**From:** Nolan, Chris <Chris.Nolan@lancashire.gov.uk>  
**Sent:** 22 September 2017 15:00  
**To:** Robert Major; planning  
**Cc:** LHS Customer Service  
**Subject:** D3.2017.0857 Lowood Whins Lane, Read BB12 7RB

Applicant: Mr and Mrs Edmond  
Planning Application No: 3/2017/0857  
Grid Ref: 376673 435074  
Proposal: Application for Outline Planning Permission for two dwellings including access (all other matters reserved).  
Location: Lowood Whins Lane Read BB12 7RB

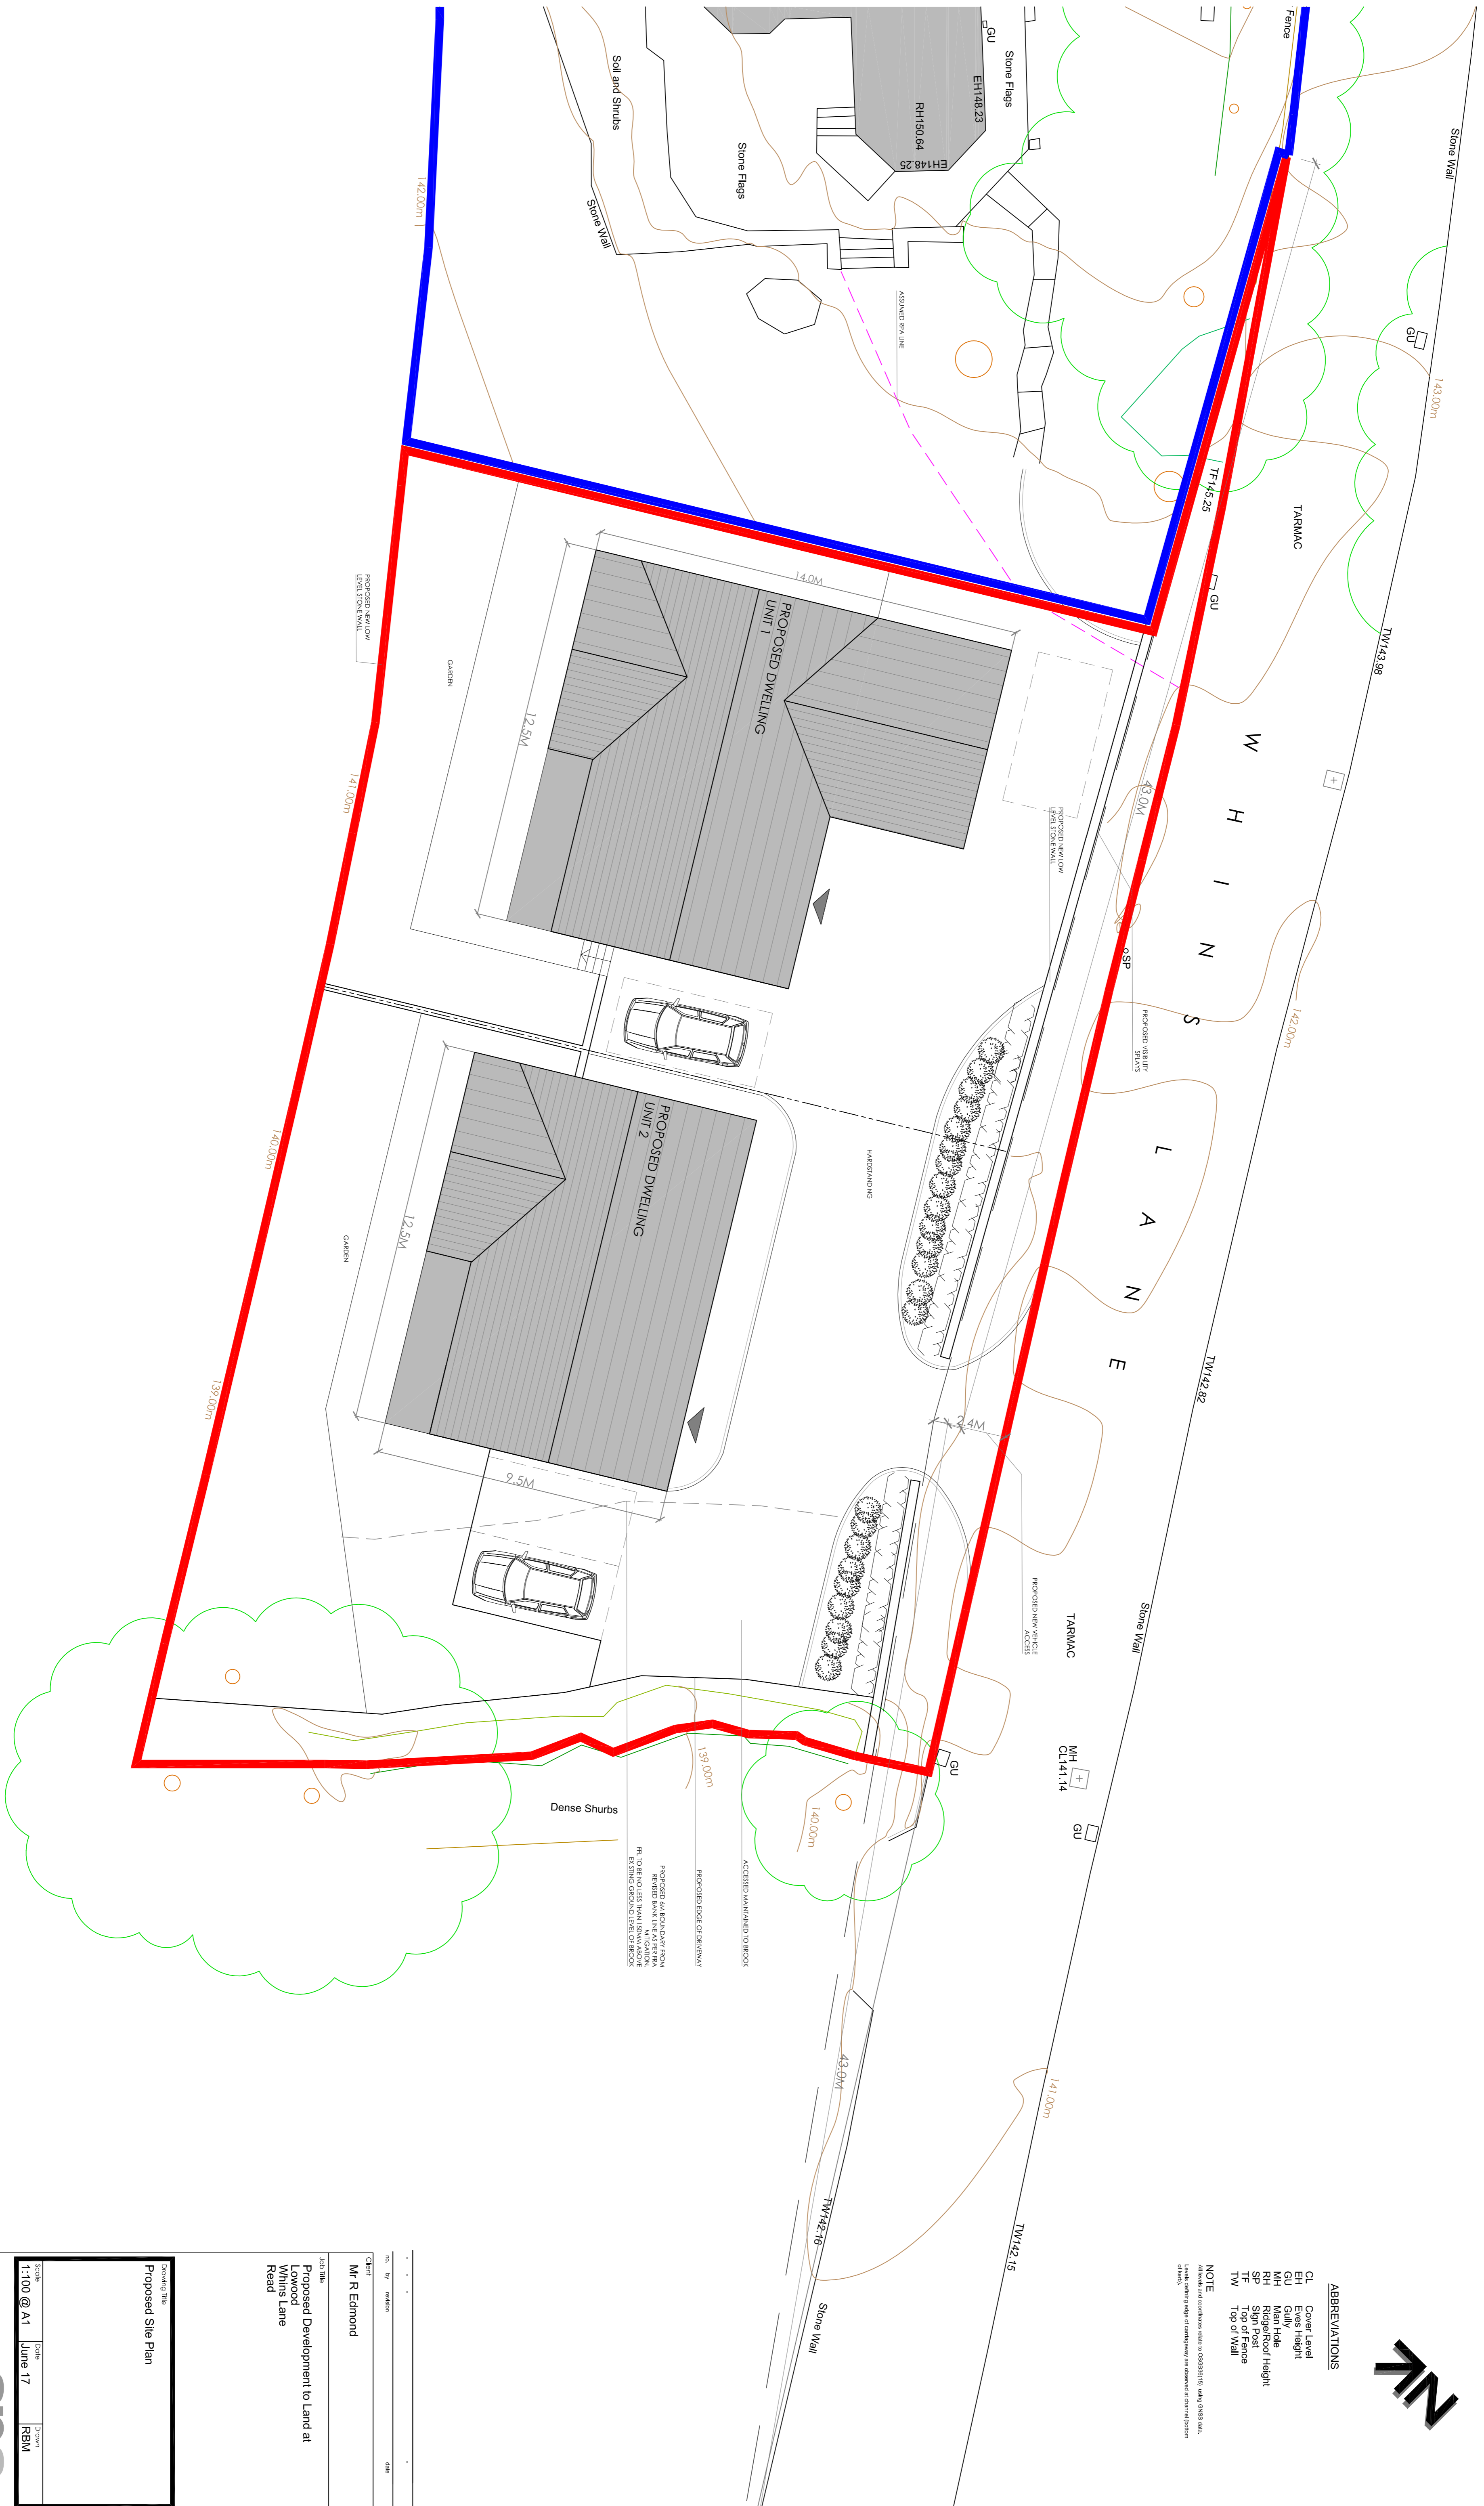
With regard to the above planning application to build two dwellings on land adjacent to the property Lowood, Whins Lane. This is an outline application with two indicative buildings. I will set my comments with regard to the indicative plan.

The submitted plan is for both properties to share an access on to Whins Lane. Whins Lane is a narrow twisting road that unfortunately attracts an amount of traffic that is making attempts to avoid the A671 through Read and Simonstone. The plans have indicated that attempts have been made to improve sightlines at the access and these would indicate that the 43m would be achieved to the west but to the east there is a difficulty where the sightline would be reliant on alterations to a third party property. As the alterations would need to be maintained in the future I feel that such a situation would need detailed agreements that may difficult to maintain in the future.

The developer has a number of options to try to get the sight lines at the access point to an acceptable level. I would first suggest that the developer looks at any possibilities to move the access point west so that the necessary sight lines do not rely on the third party land. This will be achievable as I am willing to accept sightline calculations to be drawn from an x point 2m back from the edge of Whins Lane rather than 2.4m and for the sightline to the west of the access point to be calculated to the centre line of Whins Lane rather than the south side of the carriageway. However without data indicating the actual speed of the road I would need sightlines to the east of access to be a minimum 43m. It may be advantageous to take an automatic speed count on the road to ascertain the 85<sup>th</sup> percentile of speed on this length of Whins lane as this again may reduce the required sight lines. It must be noted that these concessions are only applicable to this site because of the general geometry of the road at the desired access point and will not be a generalised reduction in standards.

Without the problems regarding the sightlines being resolved I will have to object to application.

3. The layout of the development shall include provisions to enable vehicles to enter and leave the highway in forward gear and such provisions shall be laid out in accordance with the approved plan and the vehicular turning space shall be laid out and be available for use before the development is brought into use and maintained thereafter. Reason: Vehicles reversing to and from the highway are a hazard to other road users.

4. Before the access is used for vehicular purposes, that part of the access extending from the highway boundary for a minimum distance of 5m into the site shall be appropriately paved in tarmacadam, concrete, block pavements, or other approved materials. Reason: To prevent loose surface material from being carried on to the public highway thus causing a potential source of danger to other road users.

5. Before the access is used for vehicular purposes, any gateposts erected at the access shall be positioned 5m behind the nearside edge of the footway/carriageway and visibility splay fences or walls shall be erected from the gateposts to the existing highway boundary, such splays shall be 45° to the centre line of the access. The gates shall open away from the highway. Should the access remain un-gated 45° splays shall be provided between the highway boundary and points on either side of the drive measured 5m back from the nearside edge of the carriageway. Reason: To permit vehicles to pull clear of the carriageway when entering the site and to assist visibility.
